Subject: R-6 Small Infill Design Review – 9 Moody Street

Written by: Caitlin Cameron, Urban Designer

Date of Review: Friday, March 9, 2018

**PRINCIPLE A: OVERALL CONTEXT**

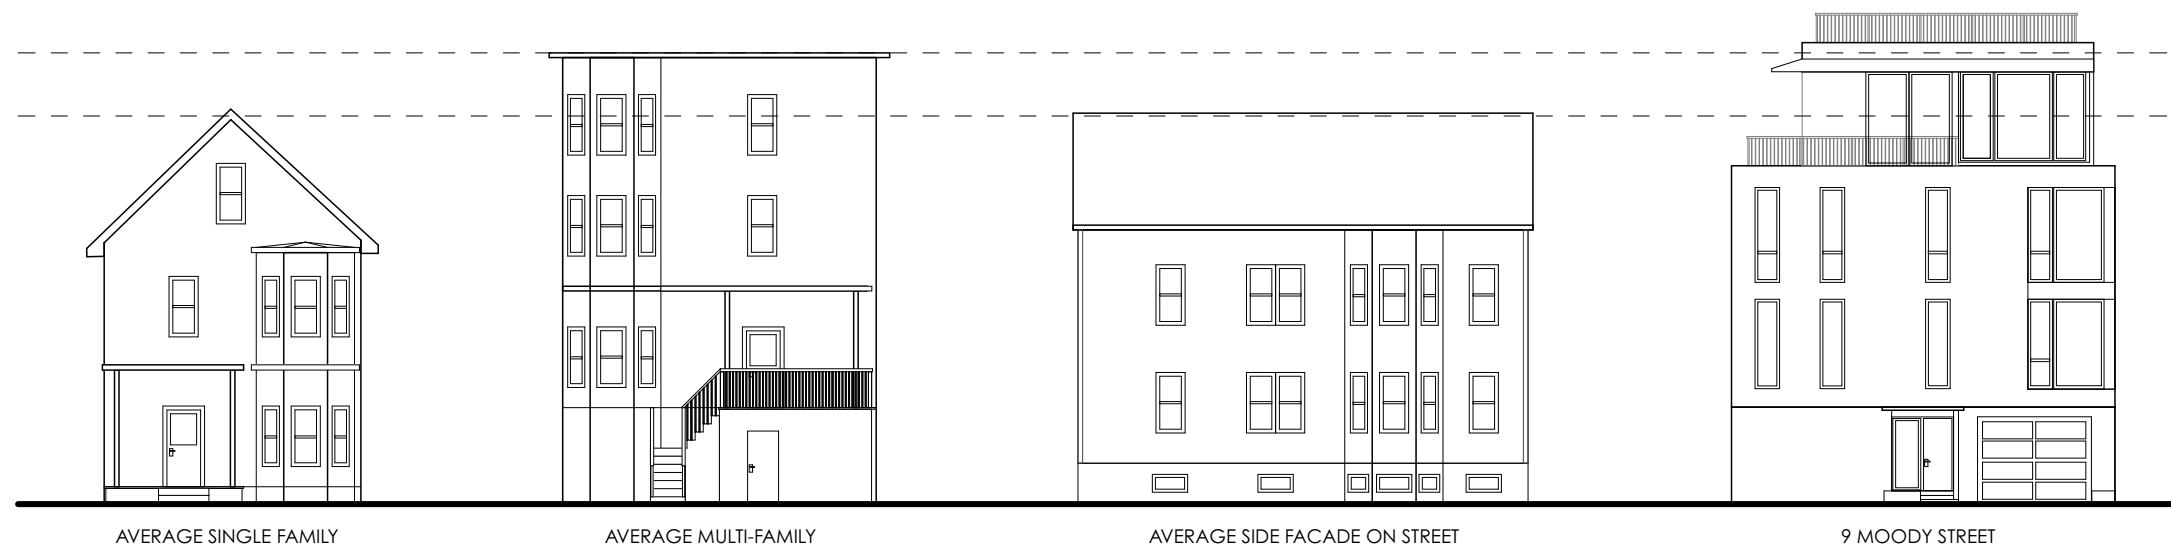
- *A-1 Scale and Form*: This residential context predominantly includes simple forms with either vertical or horizontal proportions. **The form was revised to integrate the fourth floor into the overall form as perceived from the street, and providing a clear primary roof form. Material placement and façade plane changes emphasize a three-story, vertically proportioned form at the street that relates in scale and form to the predominant one and two-family residential context.** See B Massing for further comment.
- *A-2 Composition of Principal Facades*: The composition of the street-facing façade was revised to **have a vertical relationship between the floors as expressed through the window alignment, material placement, and creation of a “bay” that ties the fourth**

floor into the front façade. Composition now emphasizes a vertical proportion by integrating the fourth floor into the “bay.” The ground floor continues to have a tall base to differentiate the ground floor garage from the upper floor living spaces.

**PRINCIPLE B: MASSING**

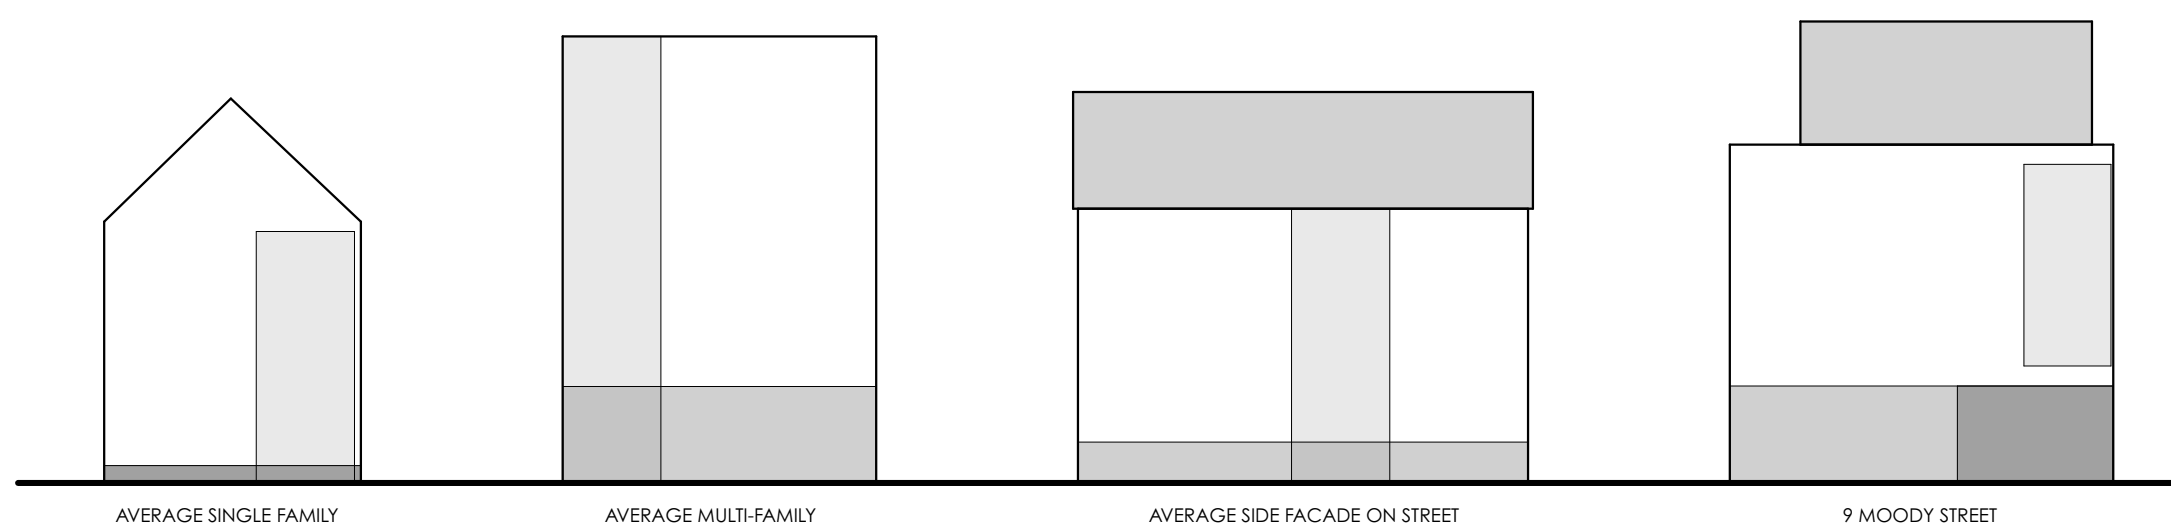
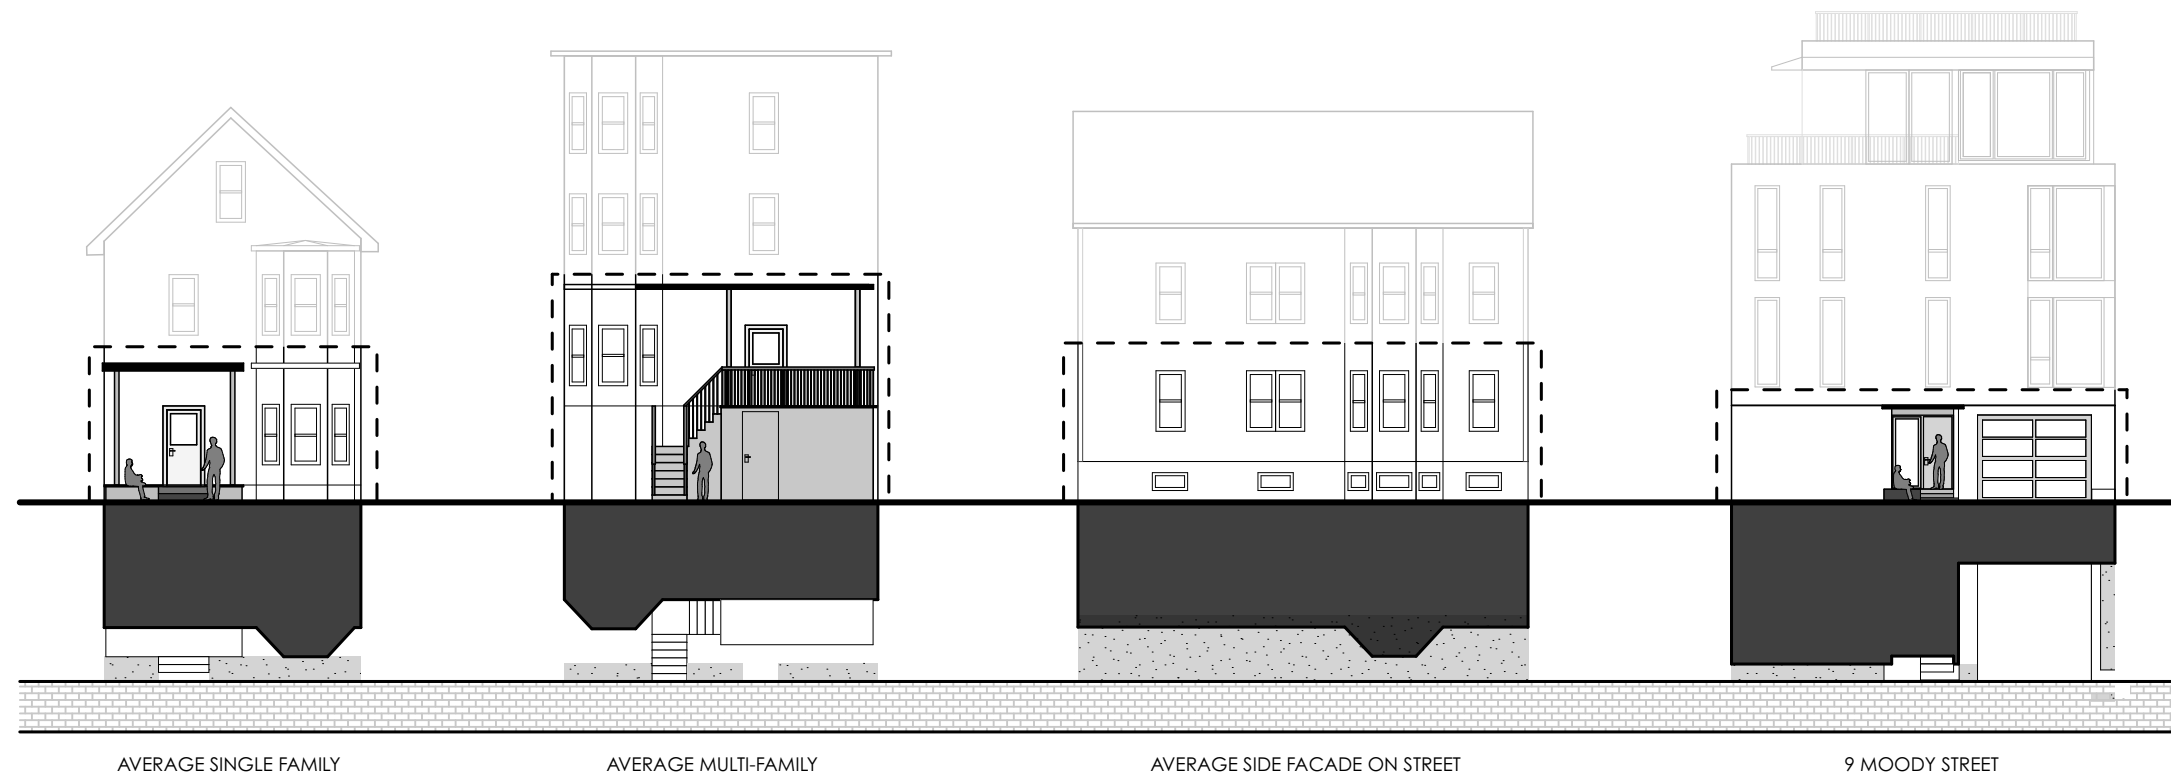
Principle B Massing – Met – Forms in this neighborhood are discernably vertical or horizontal with occasional four square buildings. **The proposed massing and material placement now emphasize vertical proportions at the street of a scale similar to traditional buildings in the context.**

- *B-1 Massing: Relationship of the 4th floor to the overall massing was revised to better knit the four floors together, provide a clear vertical orientation to the forms. The façade planes were also revised to emphasize the three-story form at the street with a proportion and scale similar to one and two-family traditional homes surrounding. The “bay” and 4th floor roof form are referential of the traditional triple decker forms.*

- *B-2 Roof Forms:* Flat roofs are found within the context. **Simple roof forms are the predominant form – the project does include two levels of roof, though was revised to better meet the overall intent of the Principle B.**

- *B-3 Main Roofs and Subsidiary Roofs:* **The project was revised to make the 4th floor roof more clearly the main roof form and have a relationship with the lower floors.**

**PRINCIPLE G: MATERIAL**

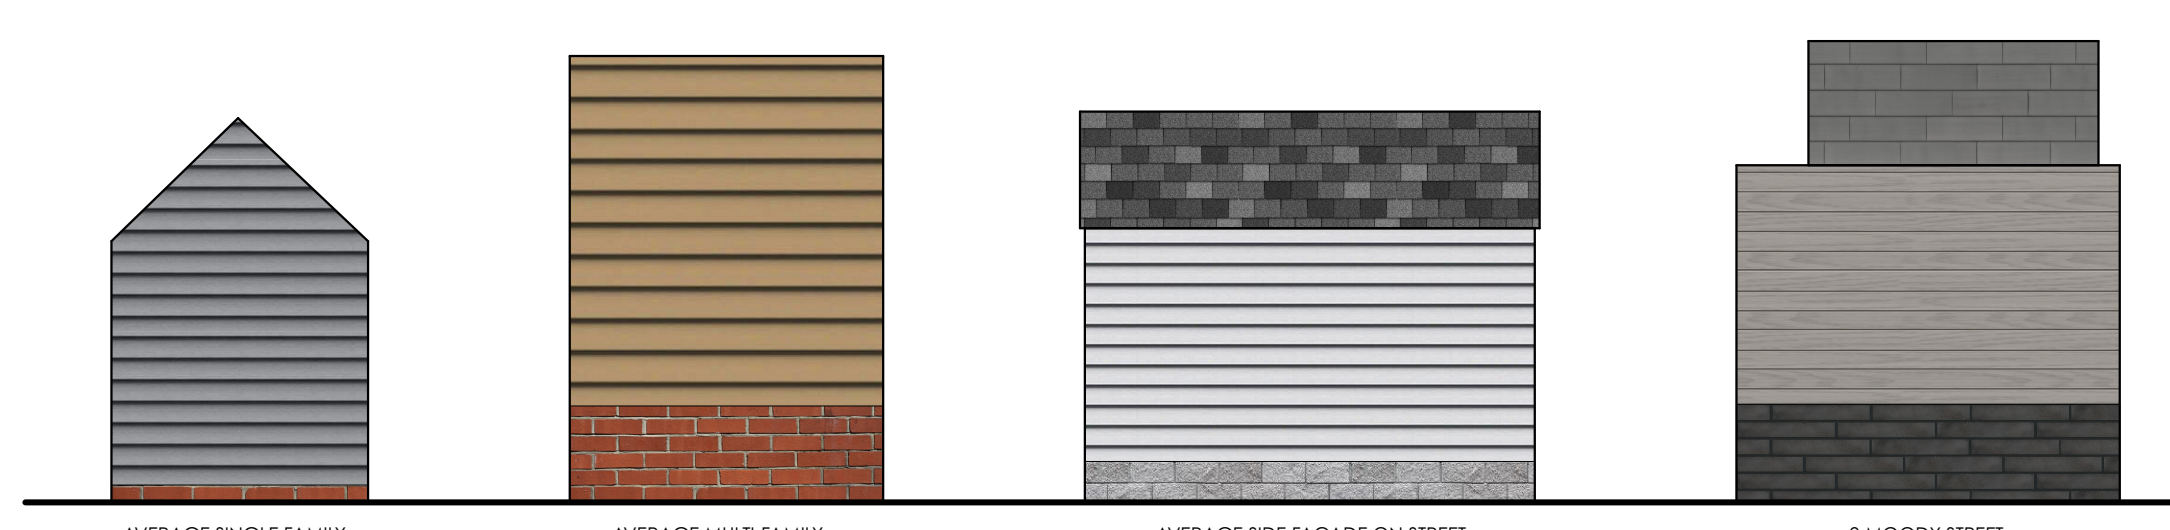
Principle G Materials – Met – The residential context is predominantly clapboard with a masonry foundation, occasional use of shingle or brick siding. Predominant in this context is simplicity of materials – generally a masonry foundation, one siding material above with occasional panel or trim to accentuate features such as a bay window or to delineate certain proportions or forms. Staff concerns regarding number and placement of materials are addressed by the revised design. Staff agree with the applicant that a lighter value on the clapboard is contextual and prevents the building becoming too dark overall.

- *G-1 Materials:* The proposal uses three materials – brick, clapboard, and metal shingle. Metal shingle can be considered acceptable as long as the finish is not highly reflective

and the scale of the shingle is fine grain to evoke the scale of materials found in the context.
